FIVE ESTUARIES OFFSHORE WIND FARM

SCHEDULE OF CHANGES TO THE DRAFT DEVELOPMENT CONSENT ORDER (TO REVISION D, DEADLINE 3)

Application Reference	N/A
Application Document Number	N/A
Revision	N/A
APFP Regulation:	N/A
Date	November 2024

APFP Regulation: 5(2)(k)
 Sheet No: 11 of 20

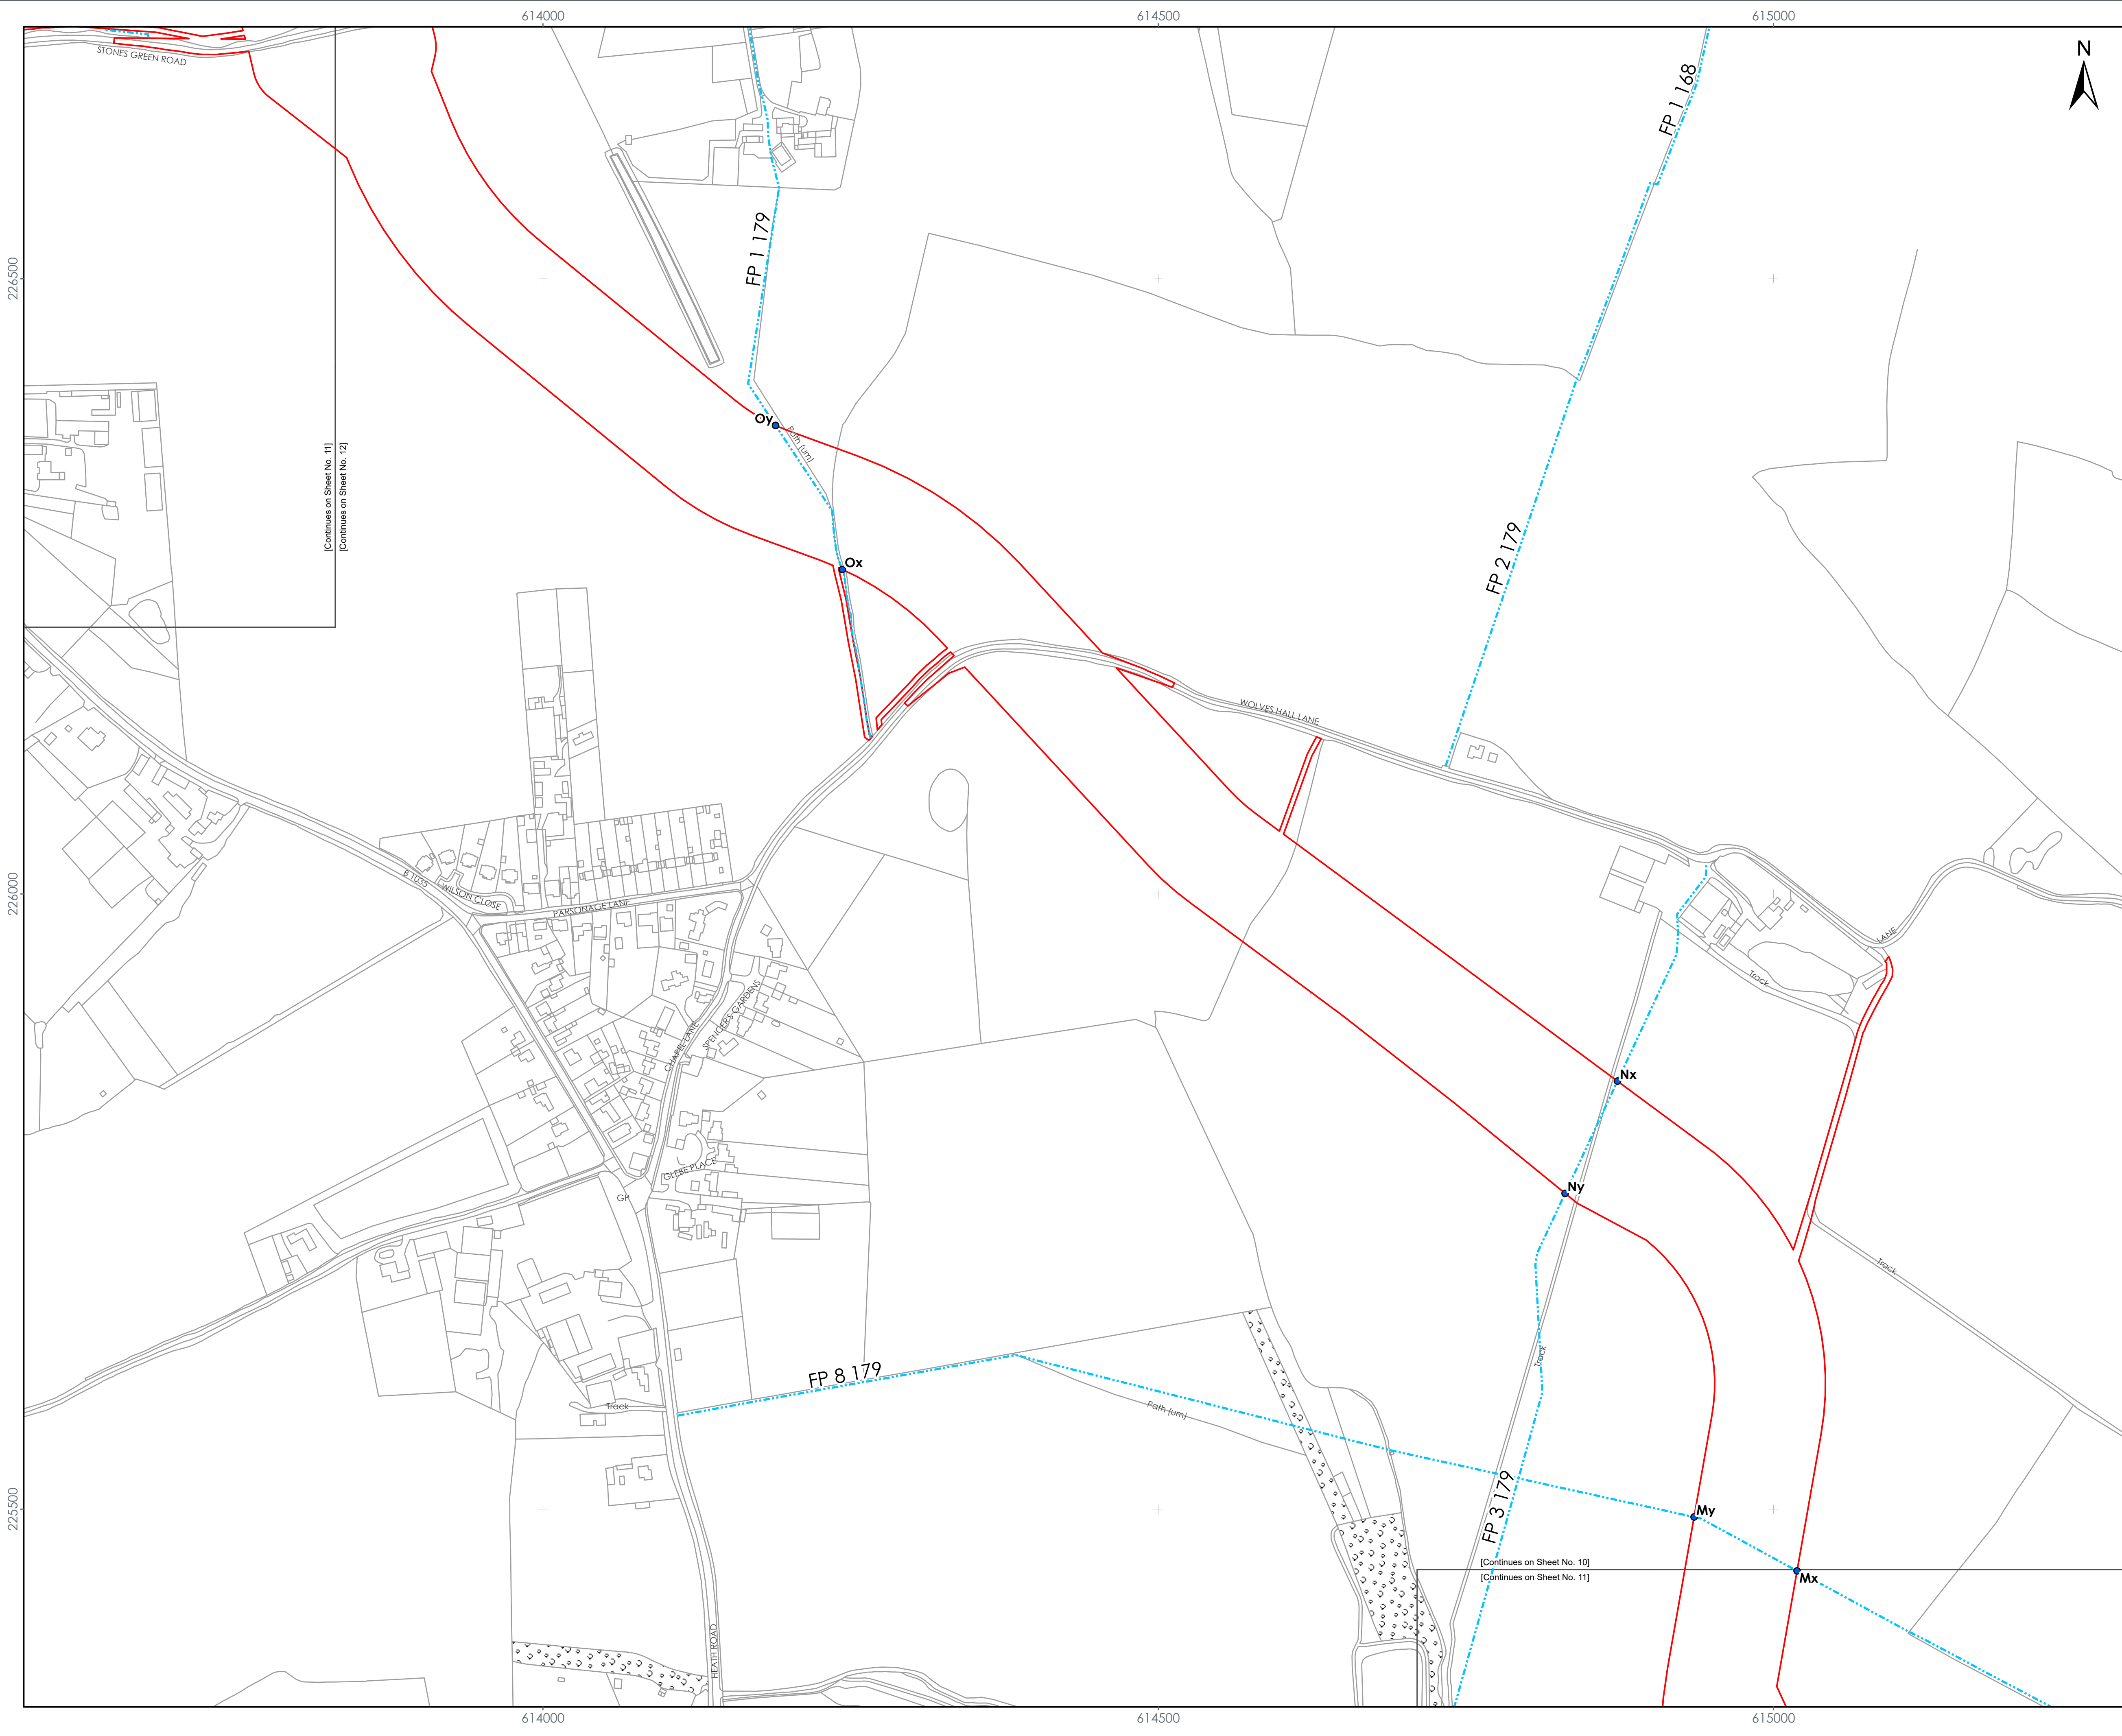
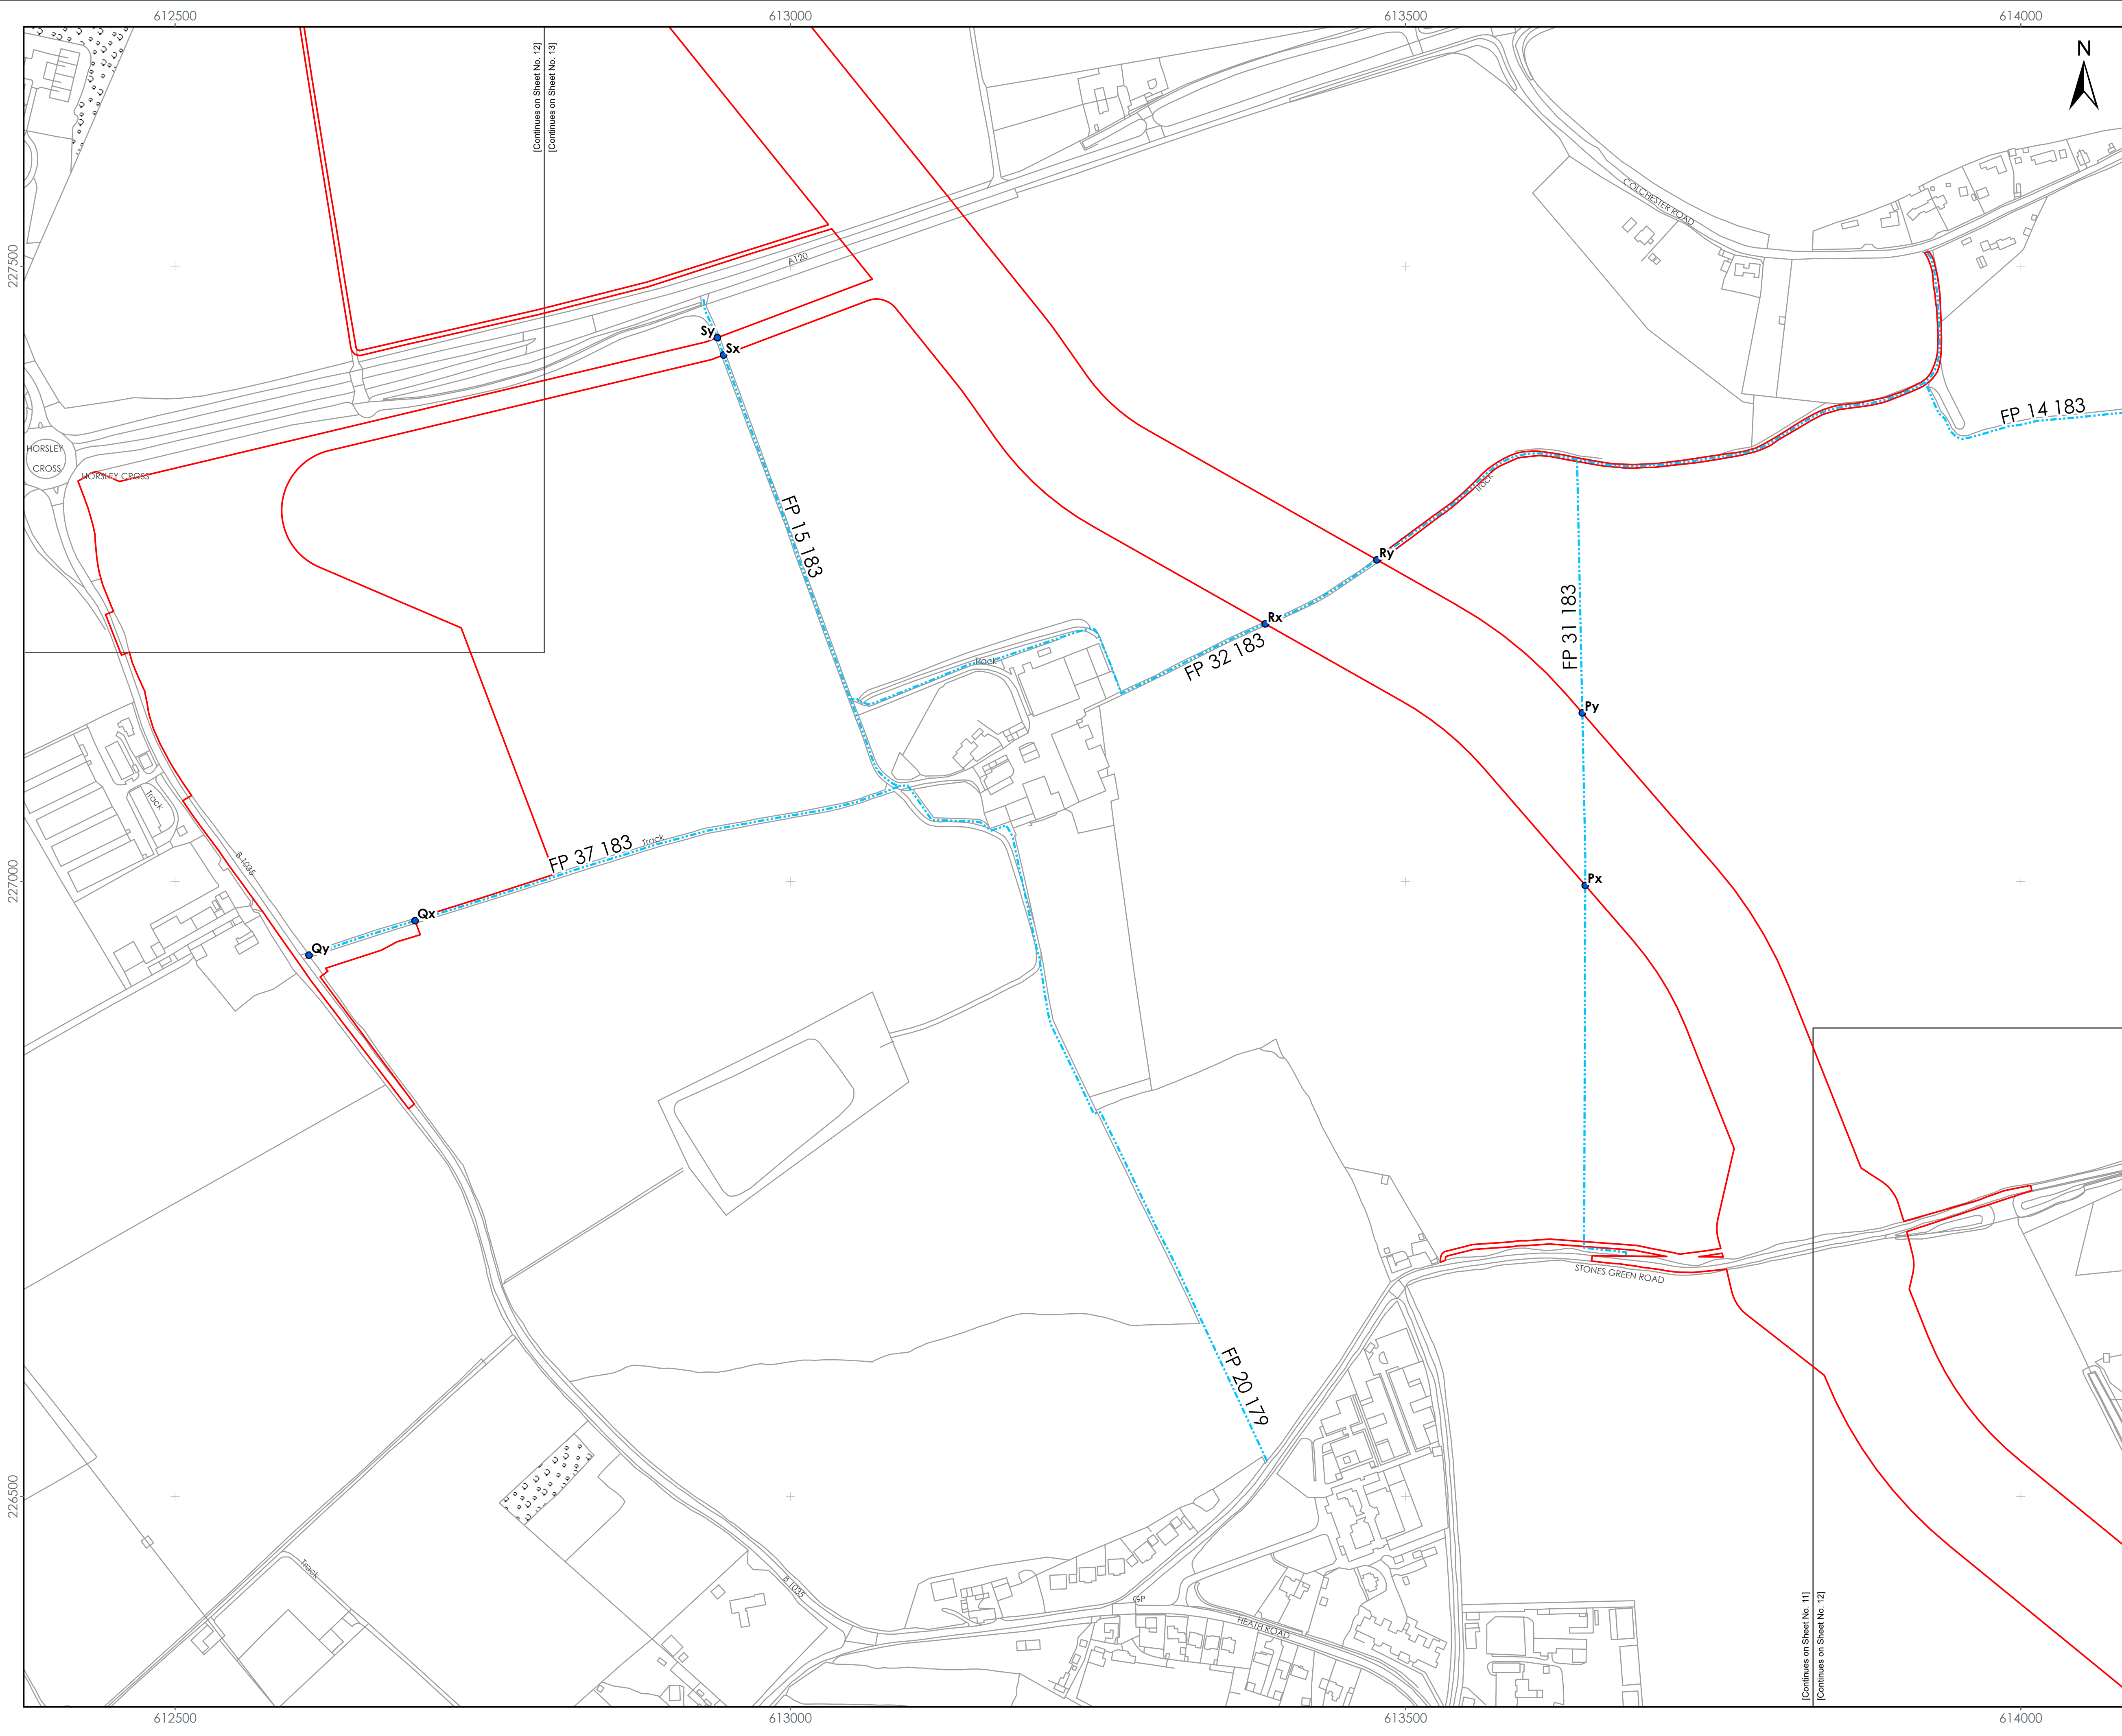
<table border="1"> <tr> <td>FP8 179</td> <td>Between points Mw to Mx and My to Mz as shown on sheets 10 and 11 of the temporary closure of public rights of way plan</td> </tr> </table>		FP8 179
FP8 179	Between points Mw to Mx and My to Mz as shown on sheets 10 and 11 of the temporary closure of public rights of way plan		
	Part 4, Speed limits	To add the additional speed limits forming part of the change request and to correct a typographic error	
	<table> <tr> <td><i>(1) Area</i></td> <td><i>(2) Road name, number</i></td> <td><i>(3) Speed Limit and length</i></td> </tr> </table>		<i>(1) Area</i>
<i>(1) Area</i>	<i>(2) Road name, number</i>	<i>(3) Speed Limit and length</i>
